# KITTITAS COUNTY FIRE MARSHAL'S OFFICE

March 11, 2015

Re: McDonald (CU-14-00005)

Upon review of the above mentioned land use action, I have the following comments/requirements;

1006 Emerson Rd.

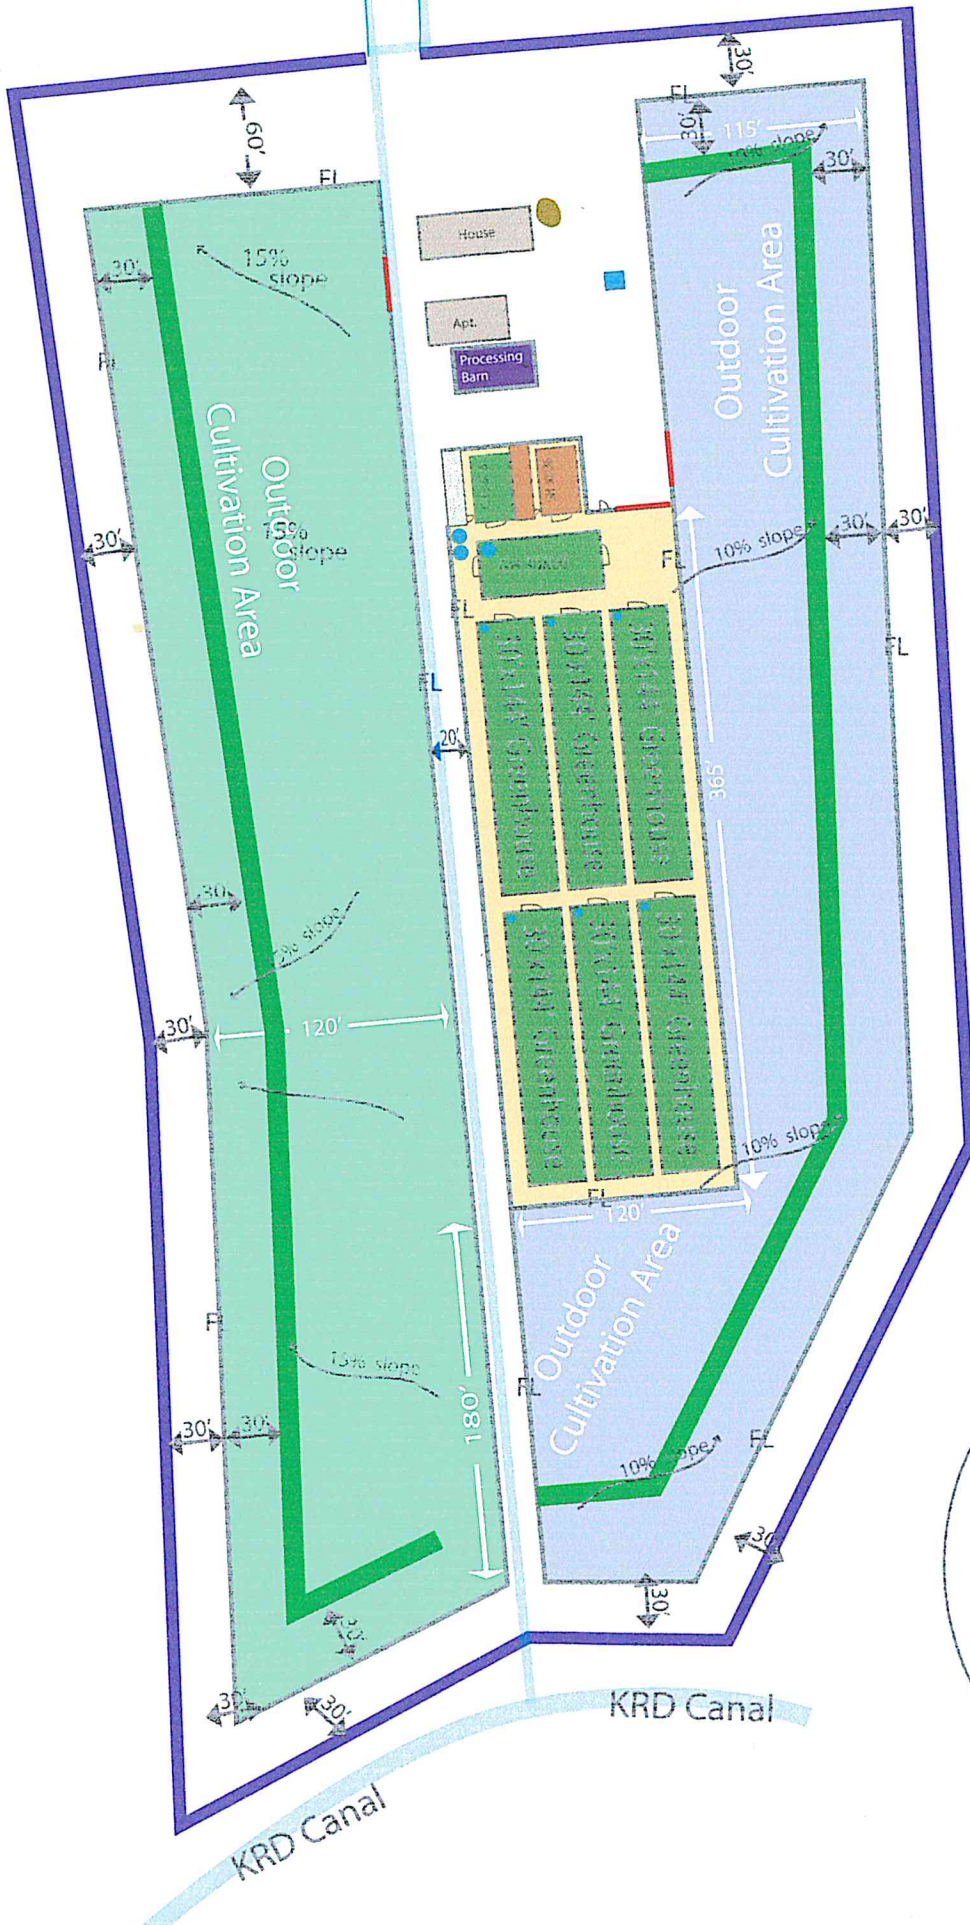
- A turn-around shall be provided for fire department access.
- Access shall be a minimum width of 20 feet between what appears to be the fence and buildings and outdoor cultivation. The gate access shall be 20' as well.
- A Knox Box will be required for fire department access to the property. Please contact Joe Seemiller at 509-933-7241 to acquire the necessary information.
- Quarterly or bi-annual inspections shall occur at the facility.
- It is unclear what the entire scope of the staging house will be for use and I will need detailed clarification on that issue. Depending on the use, a sprinkler system may be required if the occupancy classification is an "H".
- All development, design and construction shall comply with Kittitas County Code, Kittitas County Zoning and the most current version of the International Fire & Building Codes.
